Your Ref: BR/173/18/DOC

Town & Country Planning Act 1990 (as amended)
Town and Country Planning (Development Management Procedure) (England) Order 2015
Approval of details reserved by condition imposed under BR/306/16/PL relating to conditions 3-
surface water drainage, 5-landscape scheme, 6-schedule of materials & finishes, 8-refuse &
recycling bin enclosure & 9-covered & secure cycle parking spaces.
10-12 Land At Devonshire Road, Bognor Regis,

Arun District Council have decided to **APPROVE details reserved by this condition**

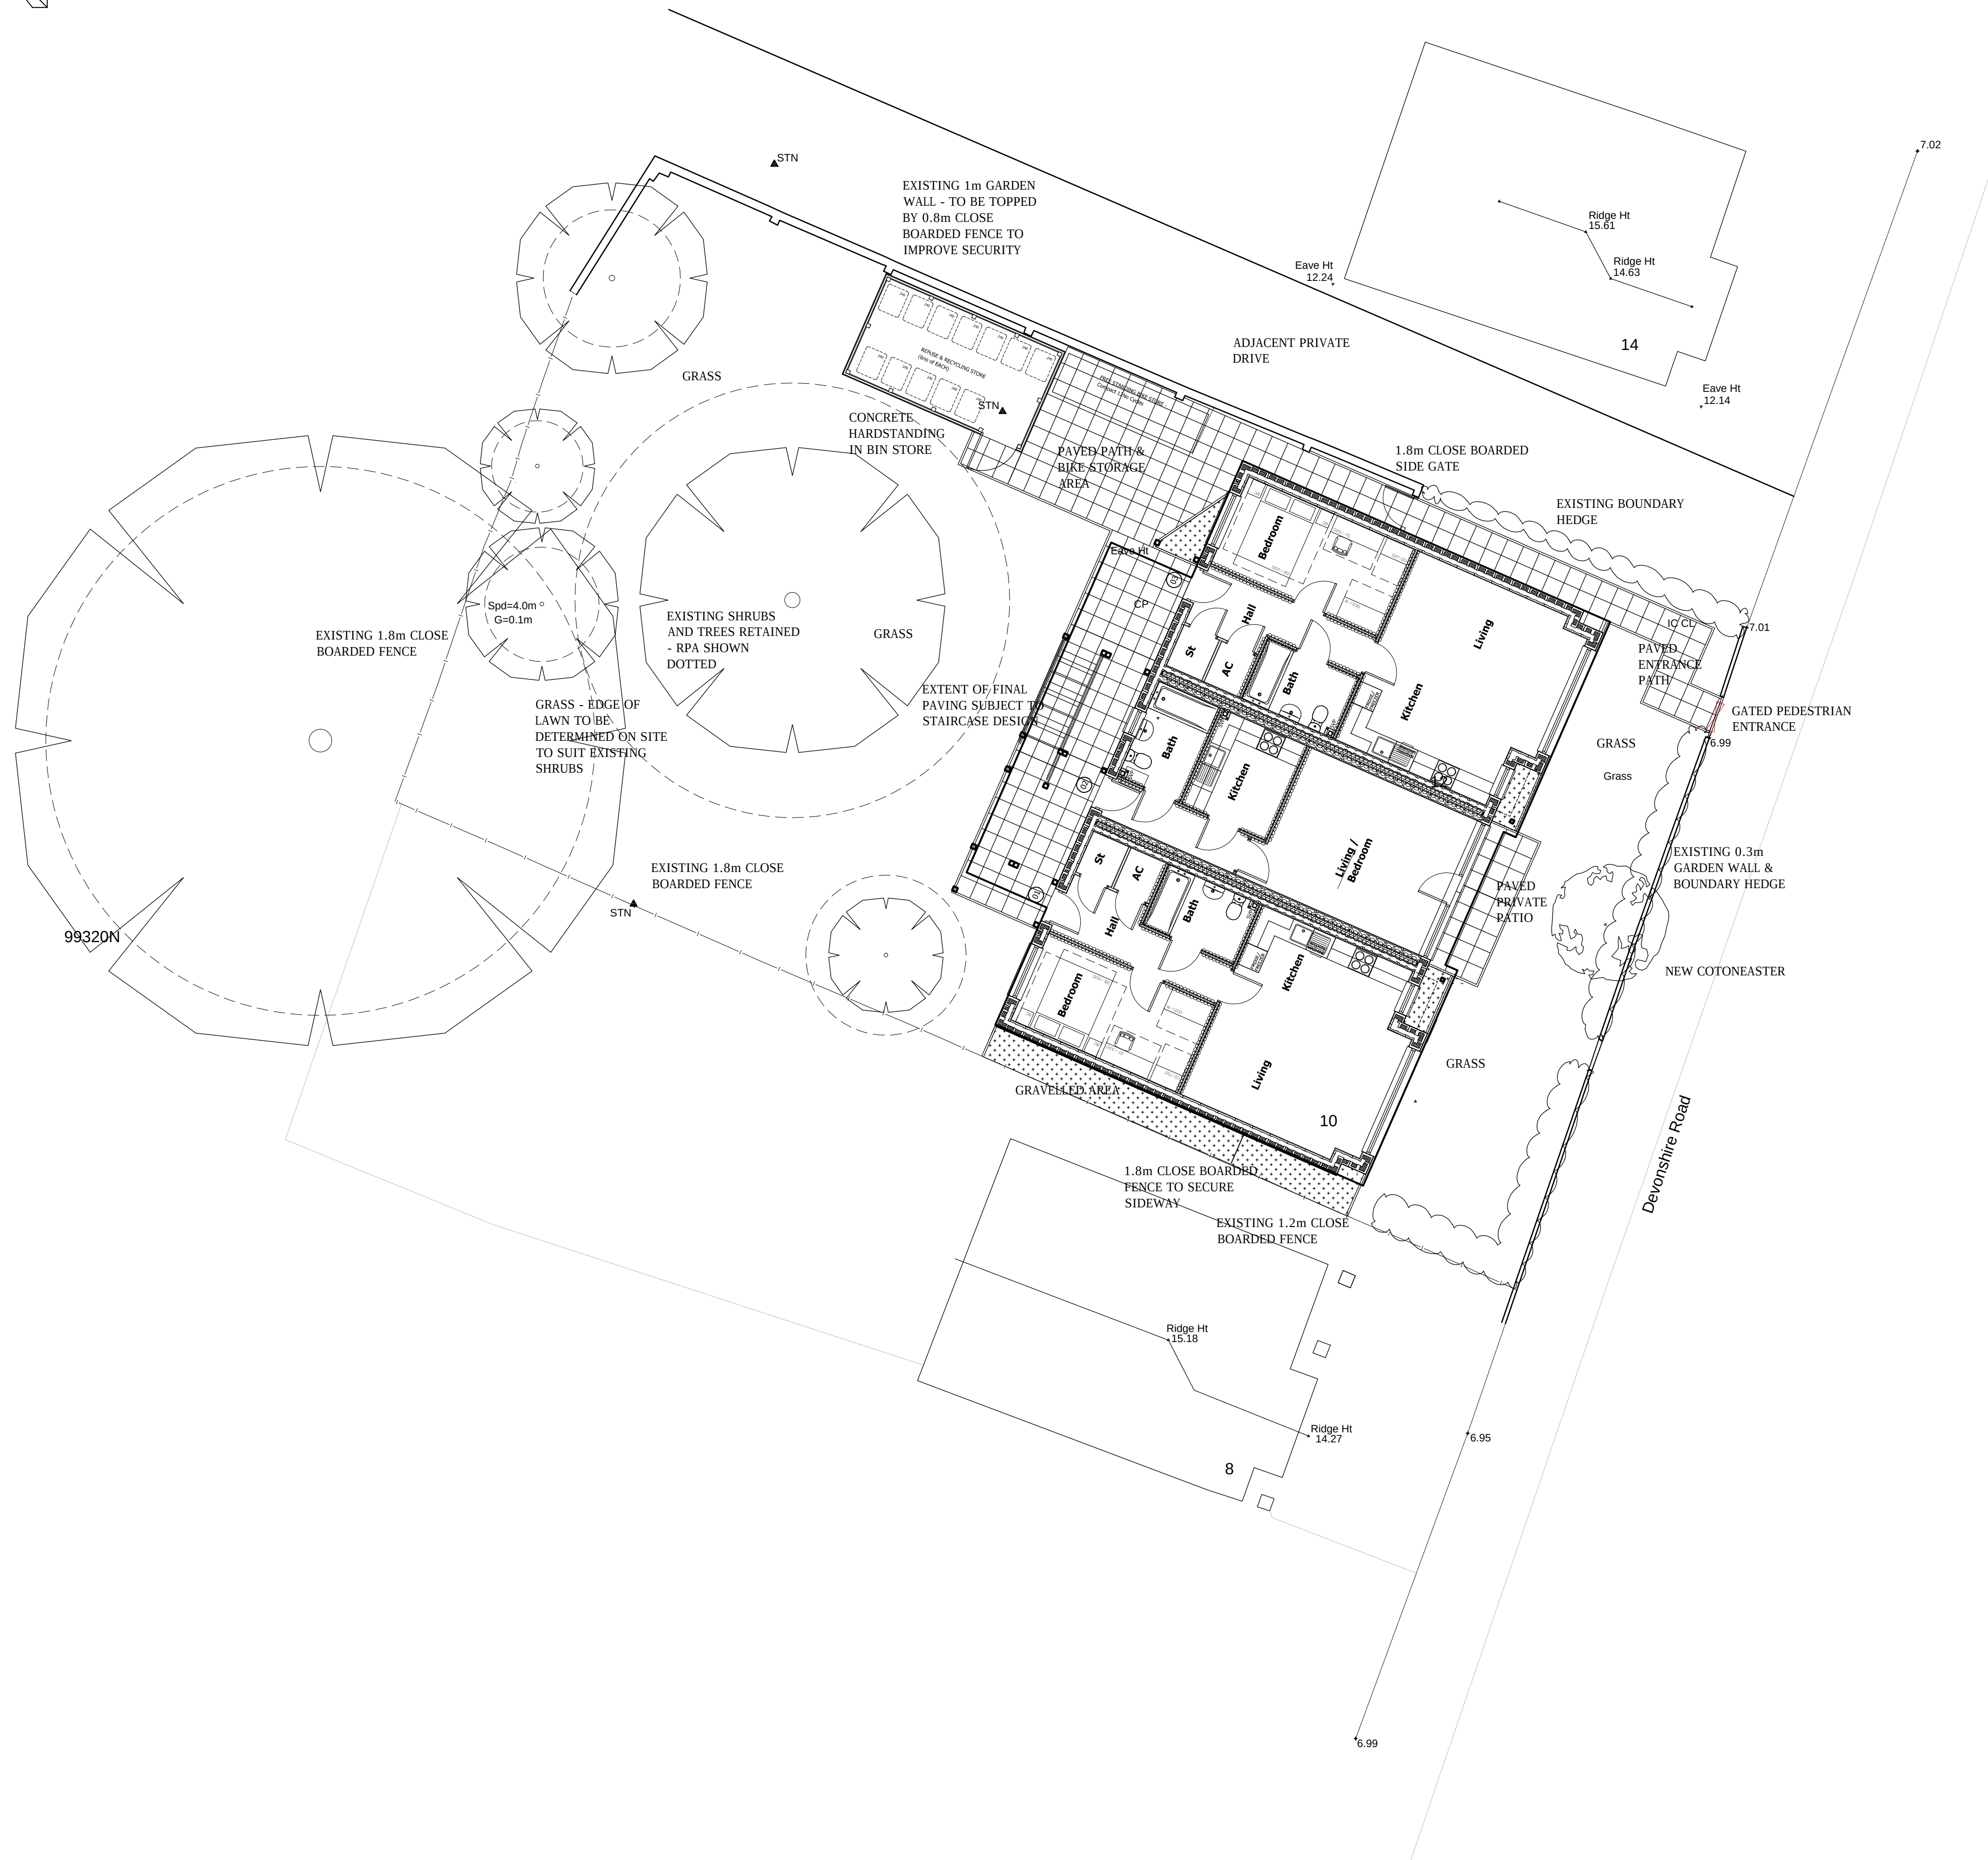
Devonshire Road Bognor Regis proposed site plan 011 C-01. 0.8m close boarded fence to be added to the top of the adjacent wall.
